EL PASO COUNTY PLANNING AND COMMUNITY DEVELOPMENT DEPARTMENT

GRADING AND EROSION CONTROL PLAN CHECKLIST

STORMWATER MANAGEMENT PLAN CHECKLIST

ROCKY TOP RESOURCES
OVERLOT GRADING & EROSION CONTROL PLAN
TRACT 7 VALLEY GARDEN SUBDIVISION
1755 EAST LAS VEGAS STREET
COLORADO SPRINGS, COLORADO

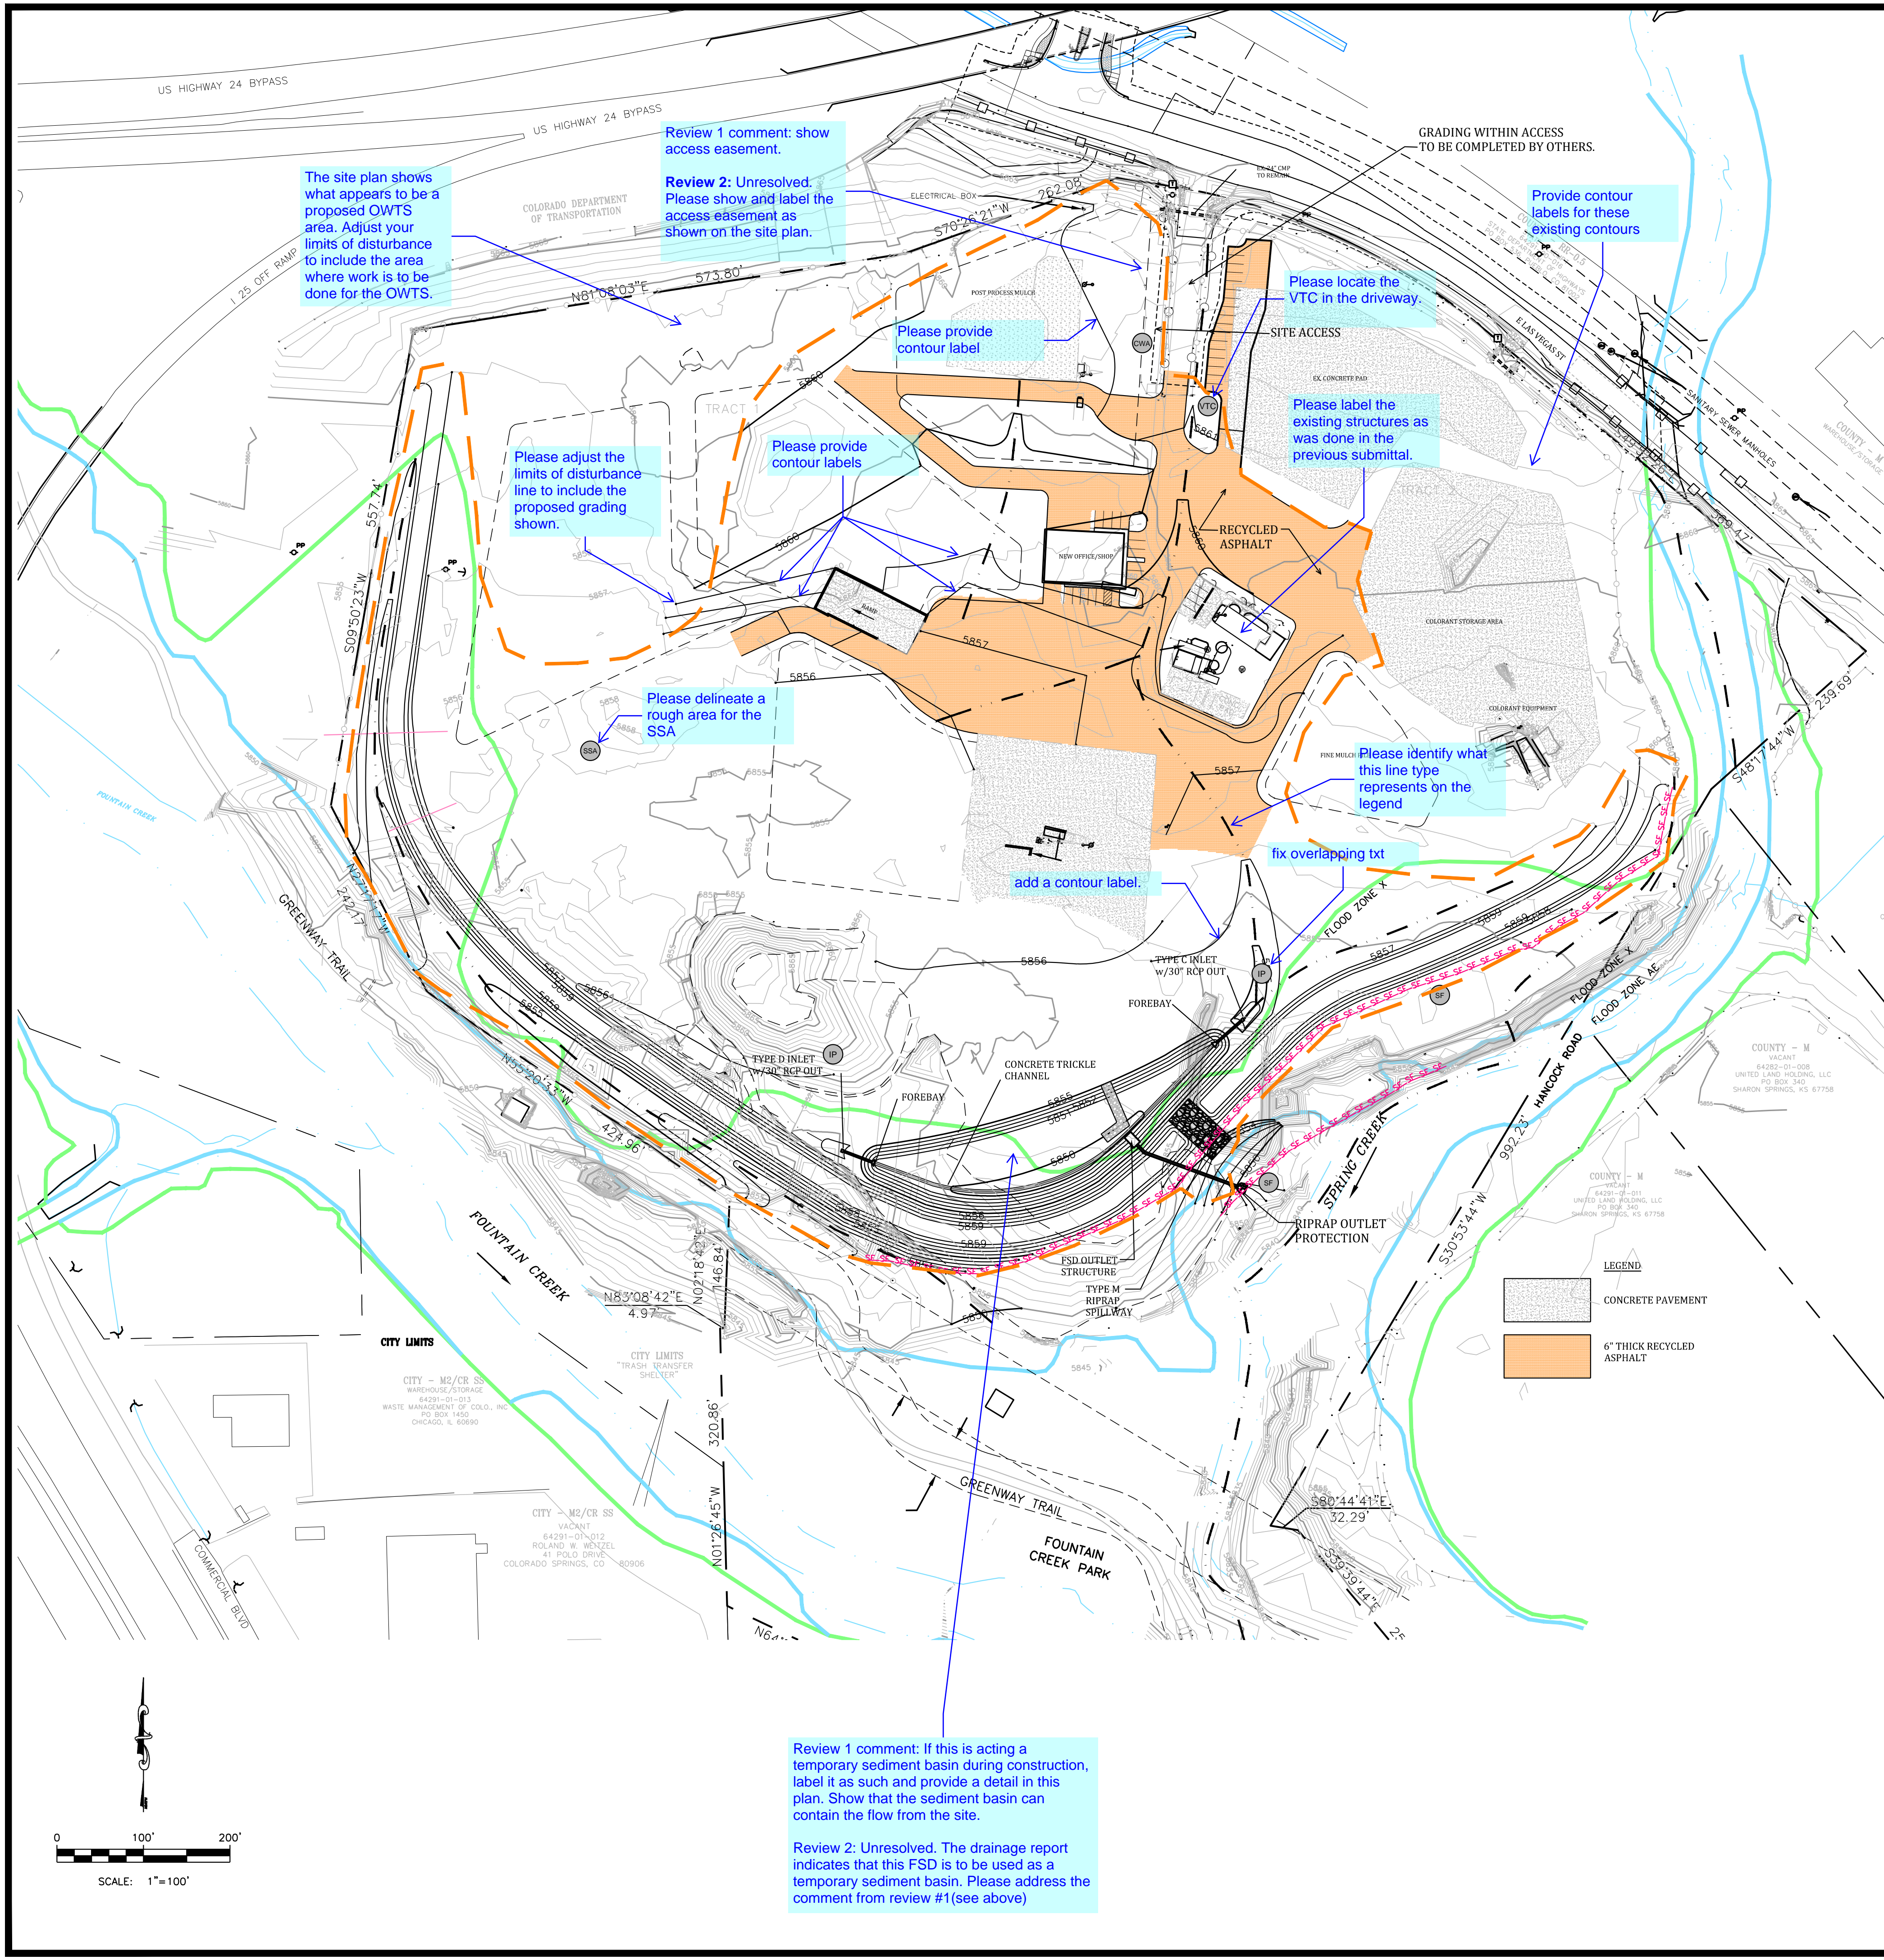
This must be addressed.
 Please show all
 existing/proposed easements
 on the GEC Plan.

Please provide flow
arrows on GEC plan.
